From: Sue Howell <Sue.Howell@arun.gov.uk>
Sent: 15 June 2022 17:02
To: Planning.Responses <Planning.Responses@arun.gov.uk>
Cc: Maria Tomalova <Maria.Tomalova@arun.gov.uk>
Subject: Planning Consultation on: AL/50/22/PL

Application ref: AL/50/22/PL

Location: Paddocks Days Lane Aldingbourne BN18 0TA

Summary recommendation: Recommend **no landscape objection** to the proposals.

Soft Landscape Layout

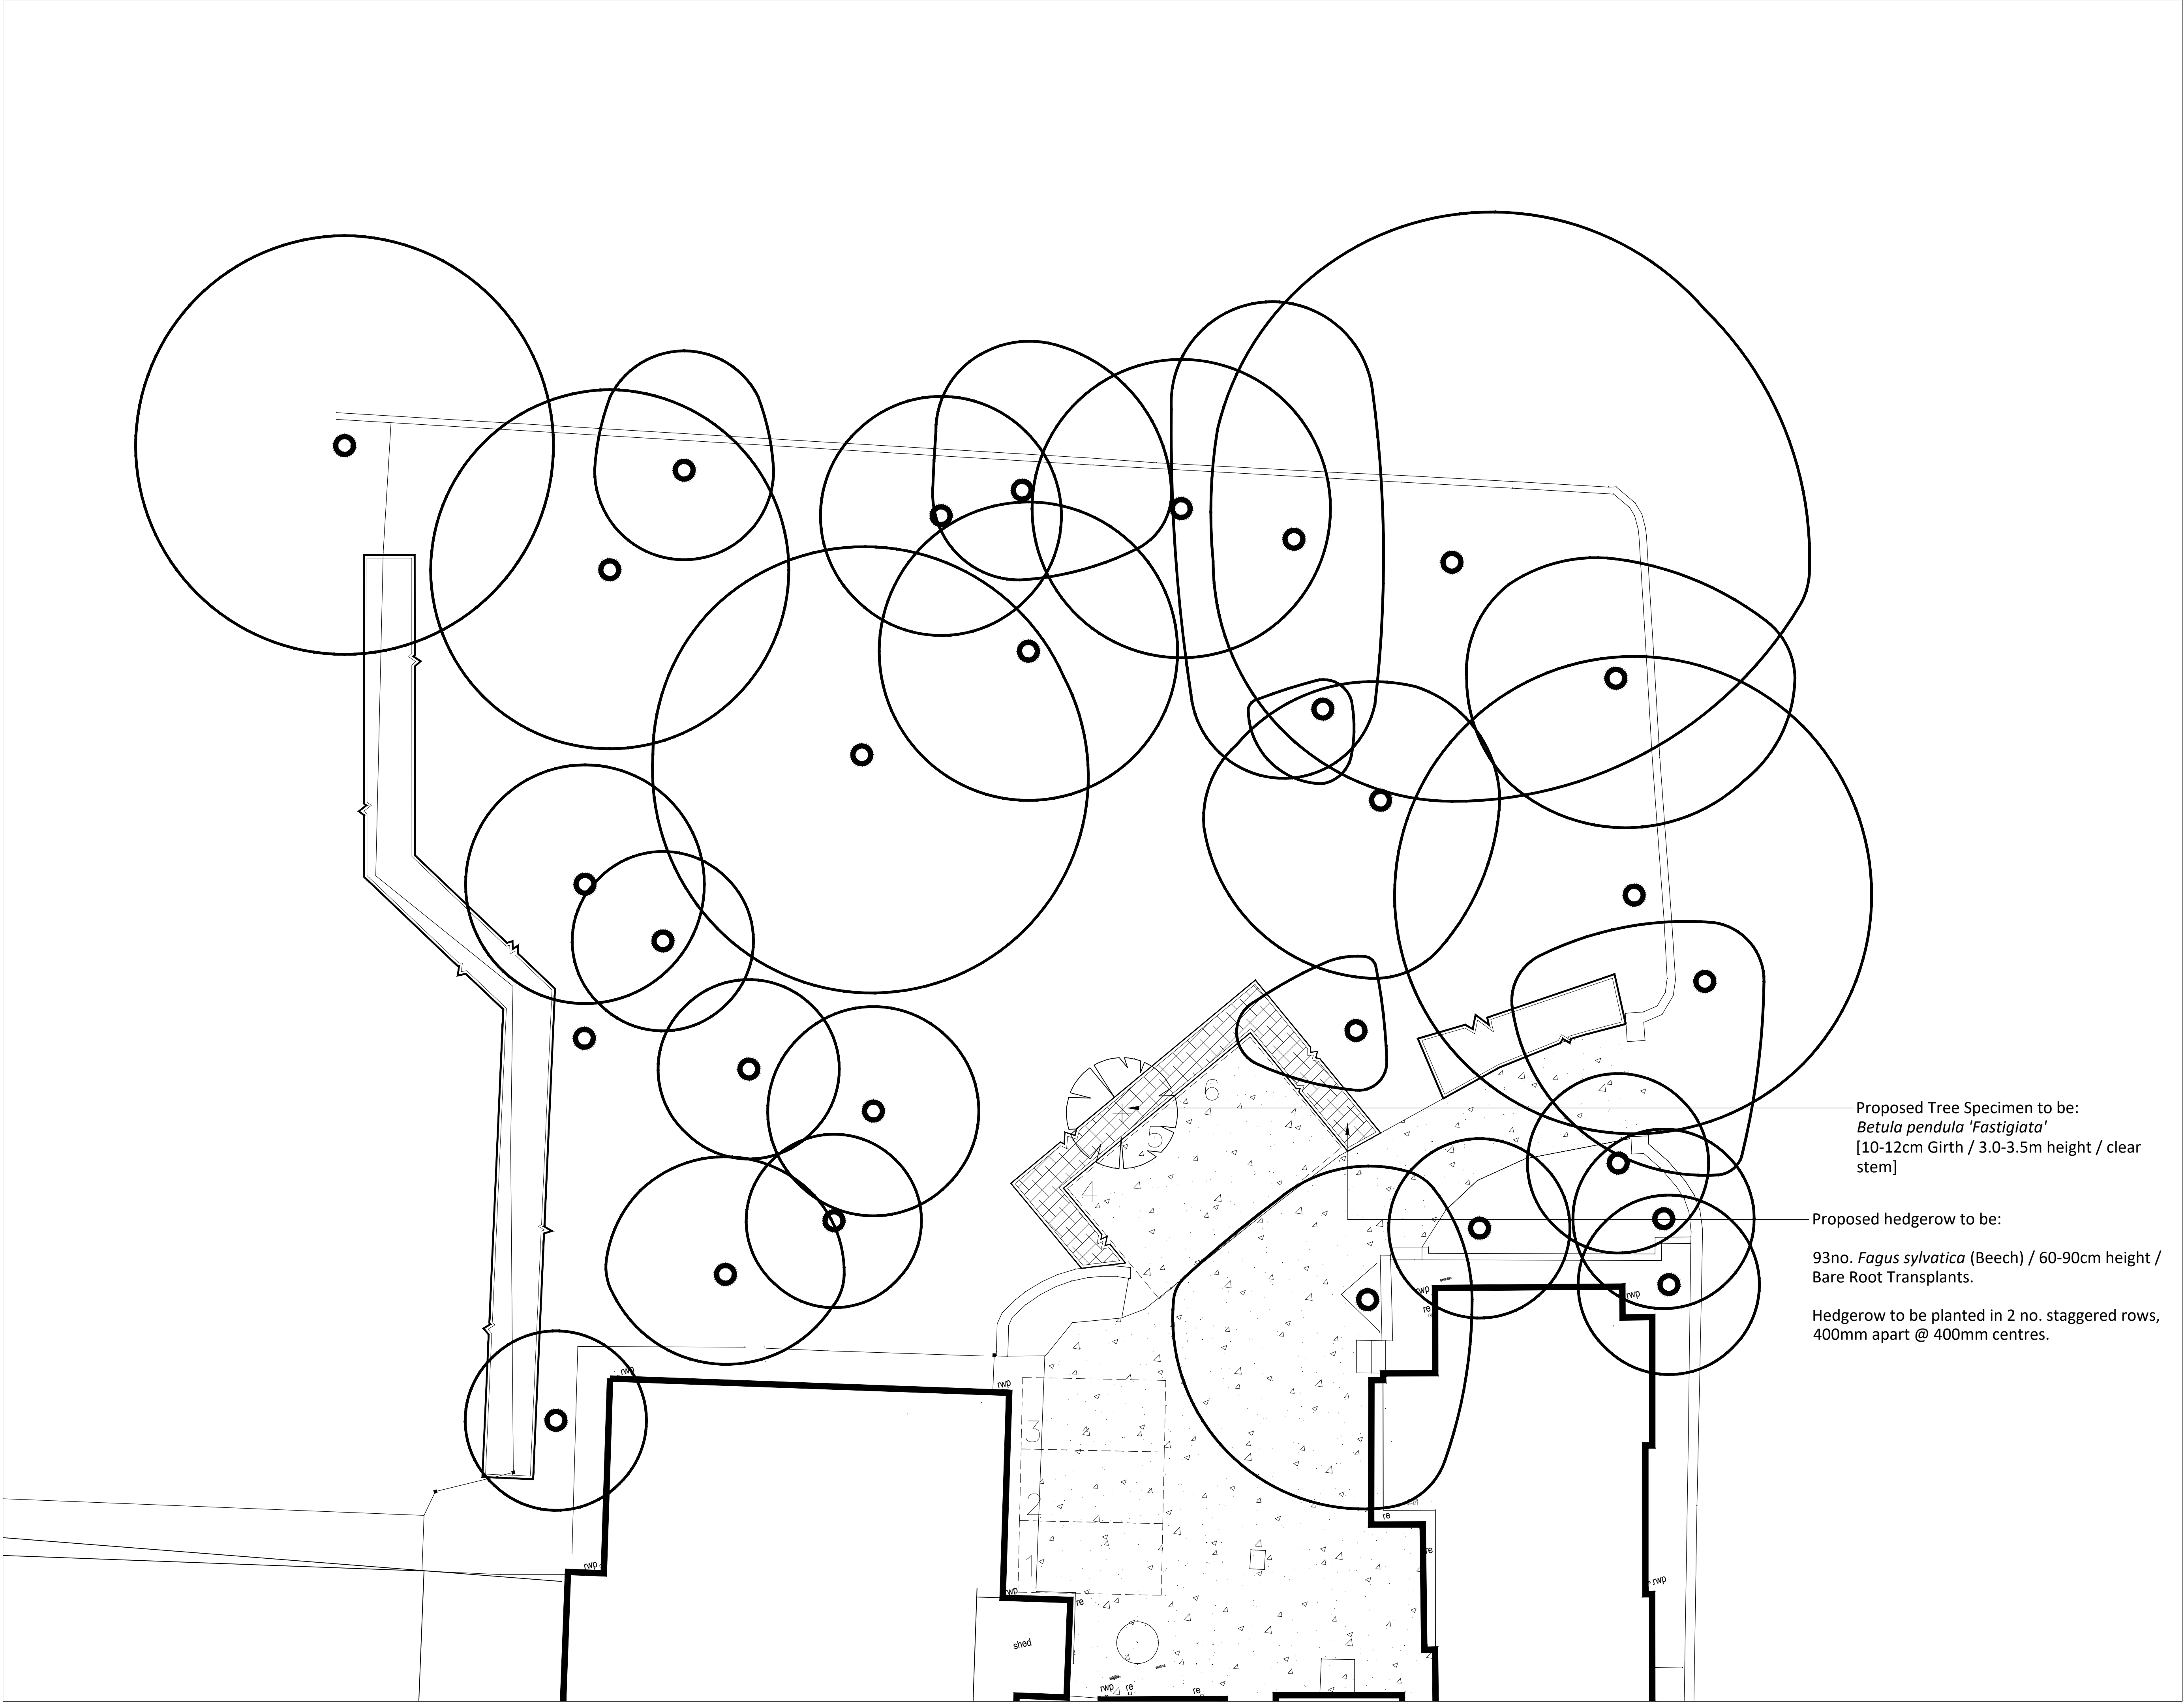
The information provided within the Soft Landscape Layout Dwg No RCo375/03 Rev 00 would appear appropriate and suitable for location, however any interface with existing tree conflict should be in consultation with the LPA Tree Officer.
